Development First floor side/rear extension, porch and canopy to front, single storey rear extension, two storey side/rear extension, external refurbishment to all principle elevations & new permeable paving to drive. Resubmission of AB/117/19/HH.

Location 54 Torton Hill Road Arundel

I regret that I am unable to accept your documents as a formal application until the following item(s) have been received or resolved :-

Drawing P04 March 2020 Scale 1:250 @ A3
Planning Drawing - Existing & Proposed Site Plan

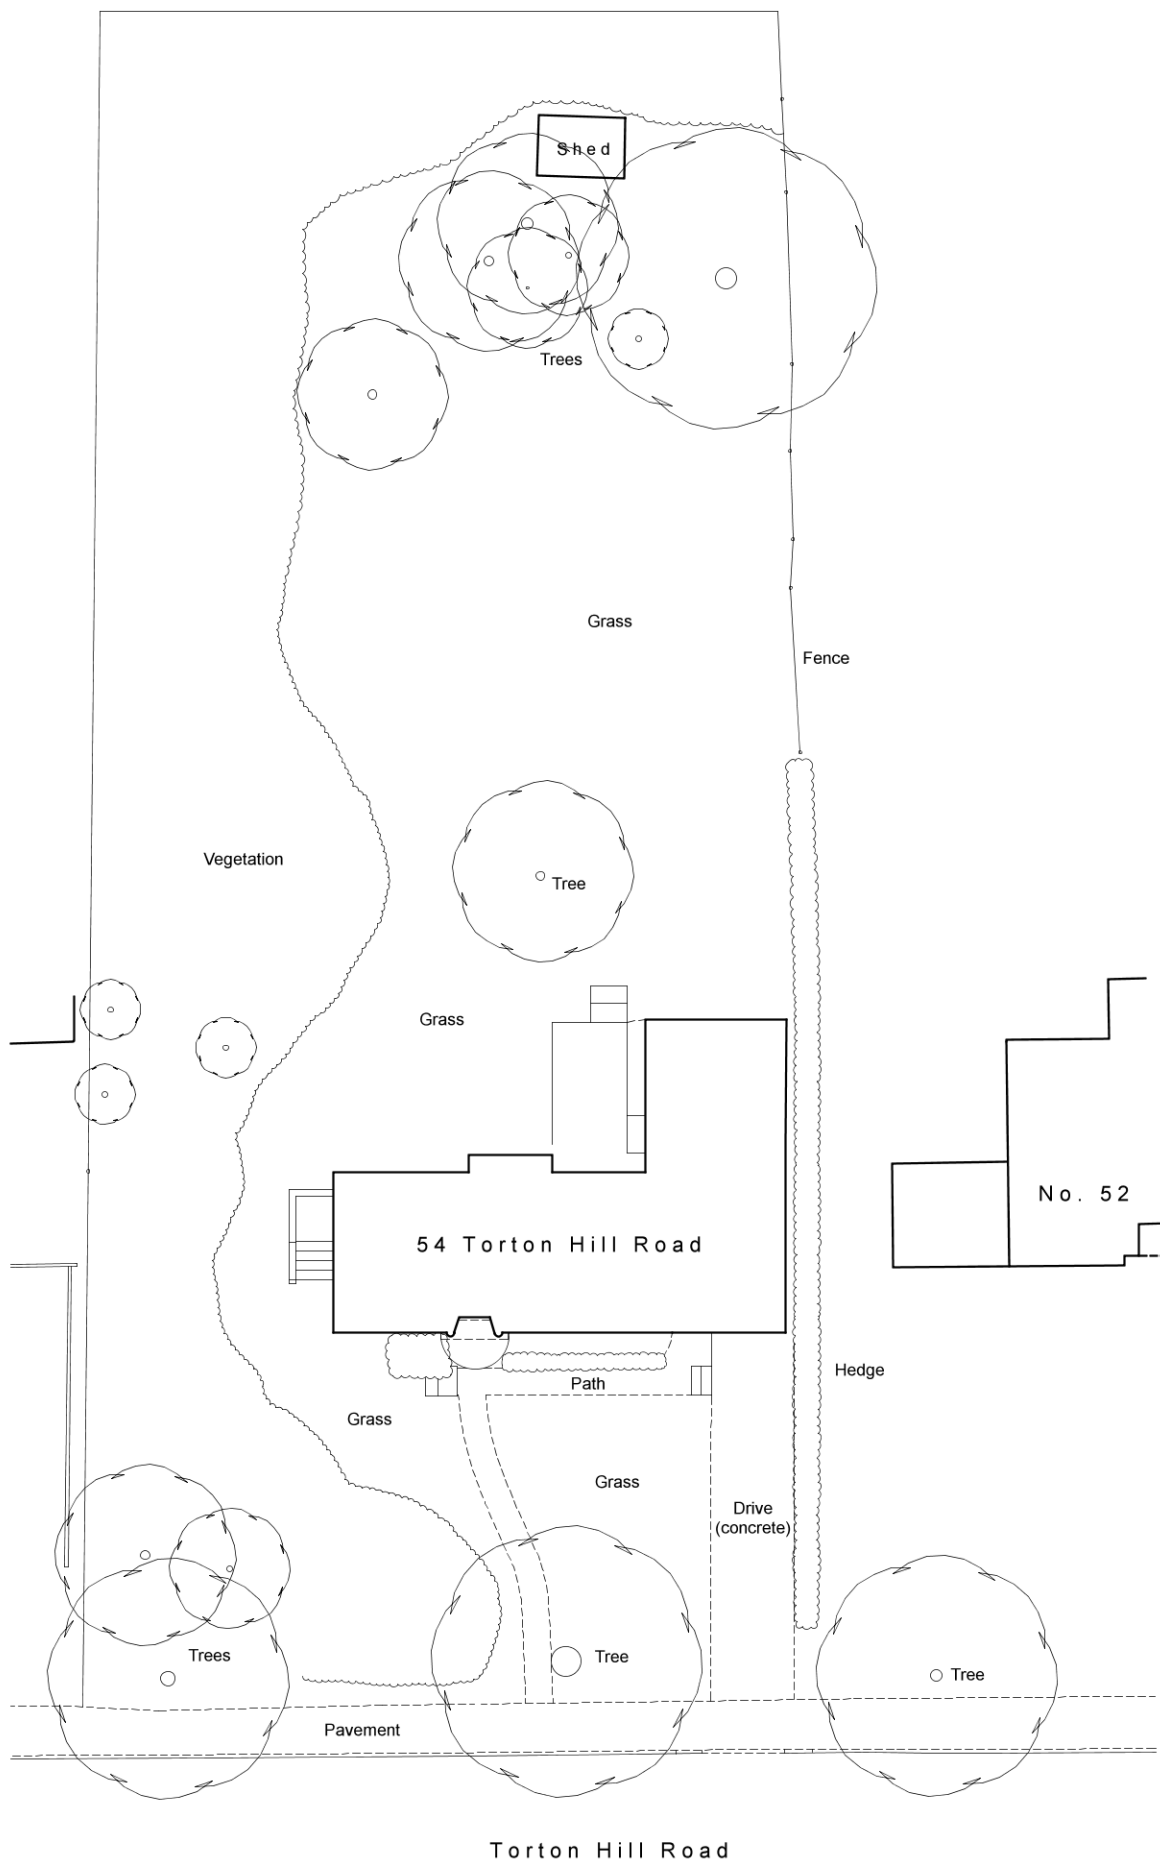
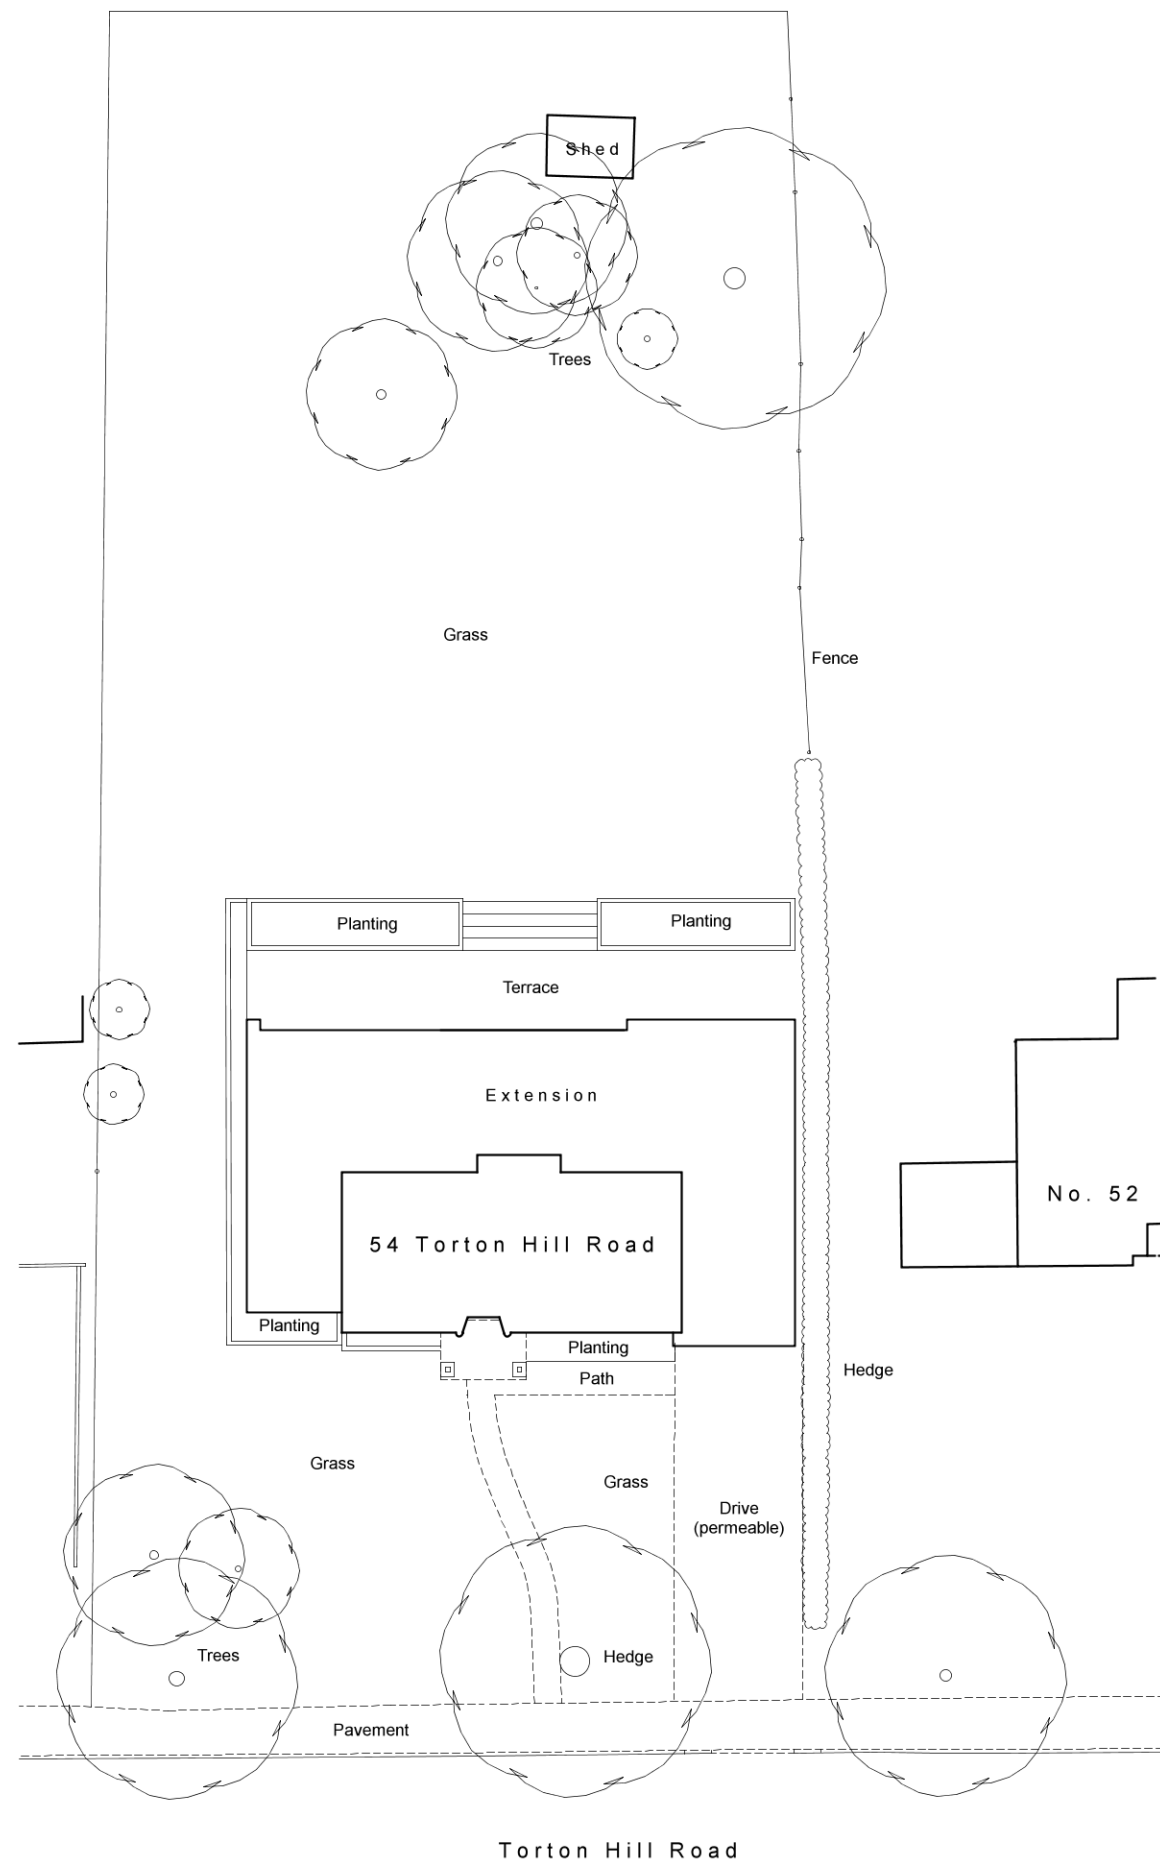
Please submit existing and proposed site plans to clearly demonstrate the changes to the drive.

Drawing P02a March 2020 Scale 1:100 @ A3
Planning Drawing - First Floor & Roof Plan & Elevations

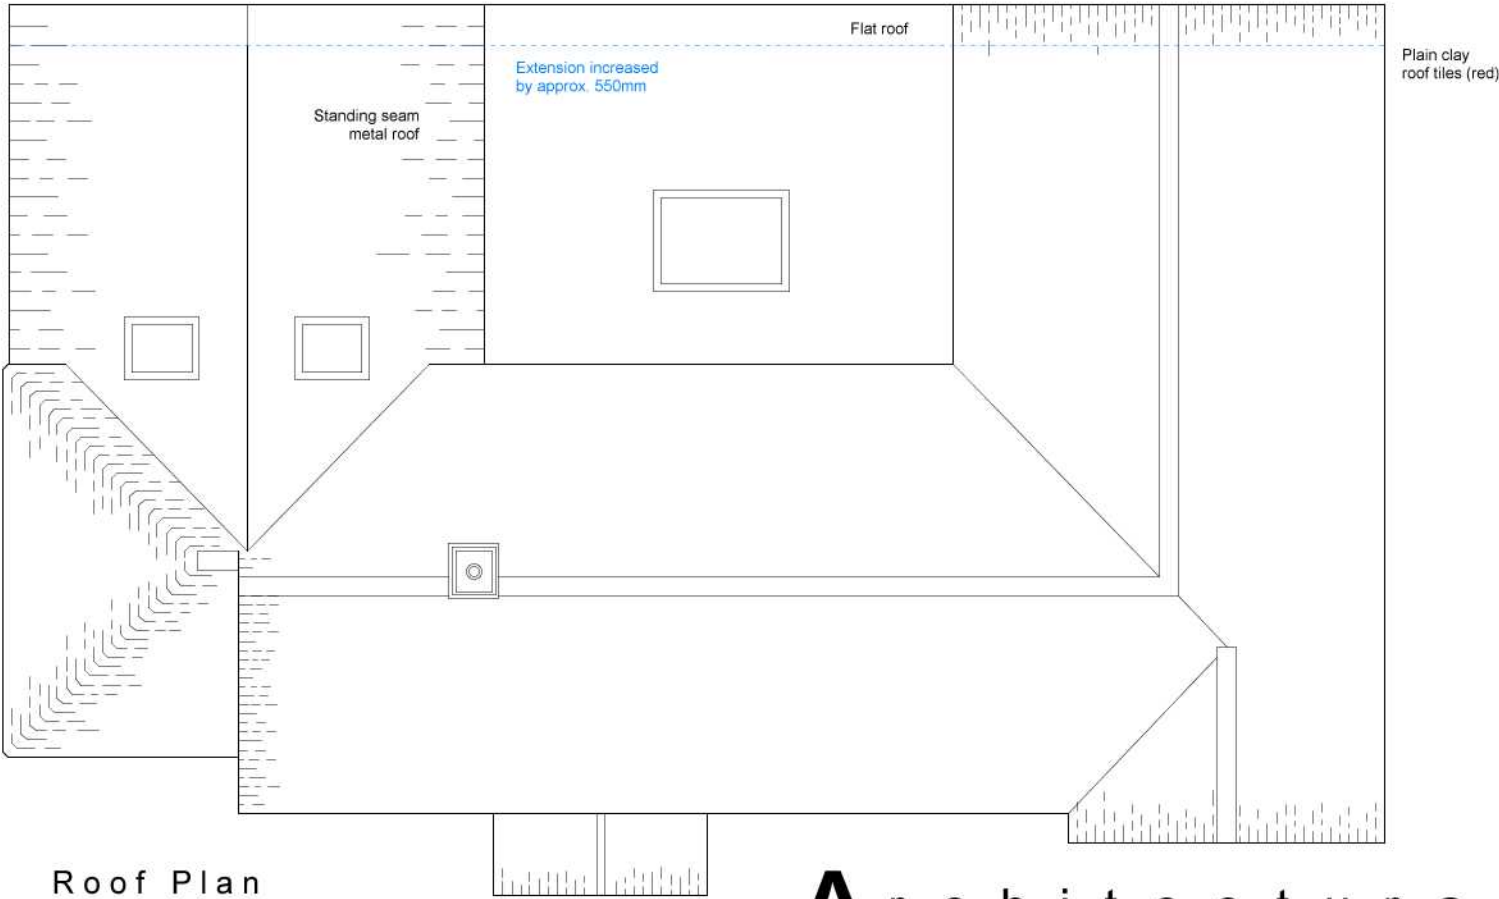
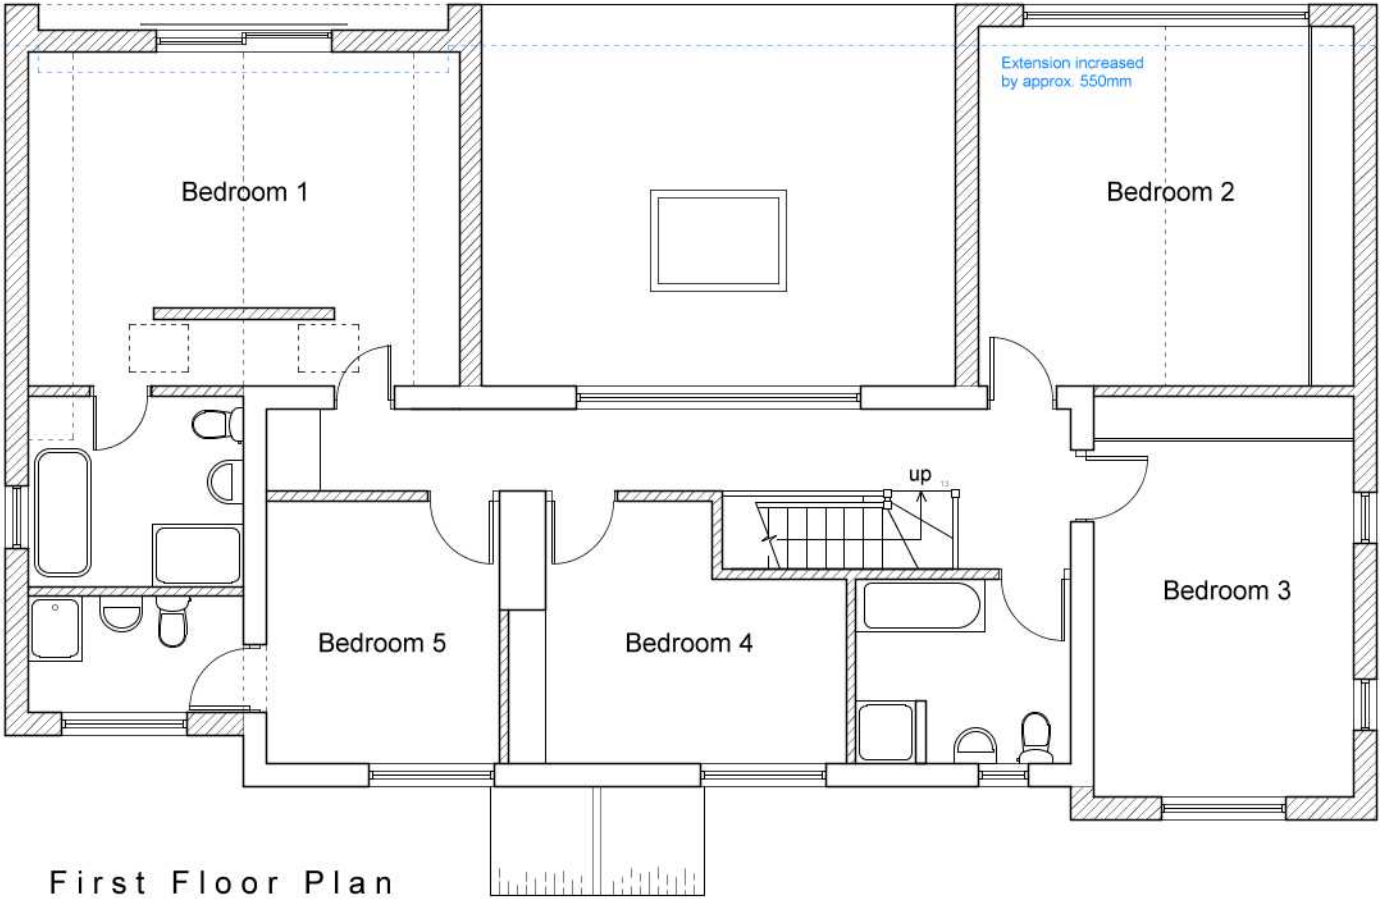
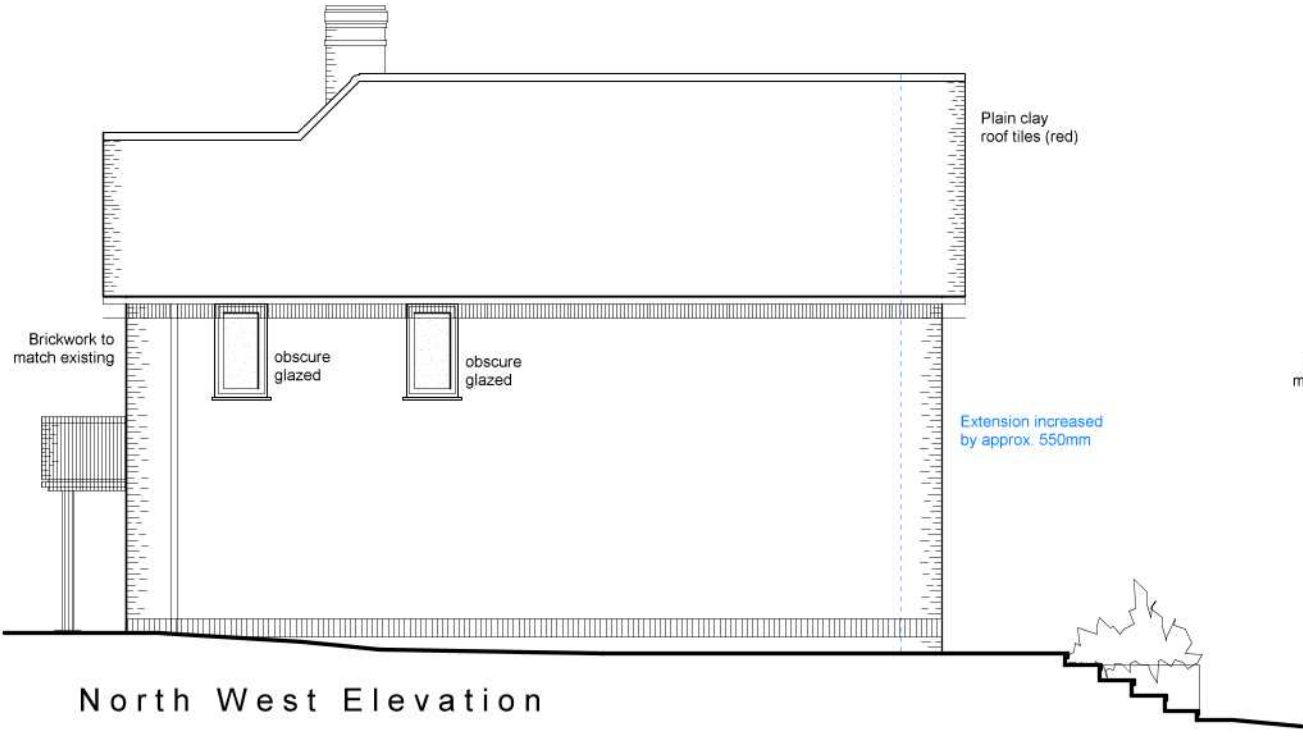
You have not submitted the proposed north west elevation. Please submit.
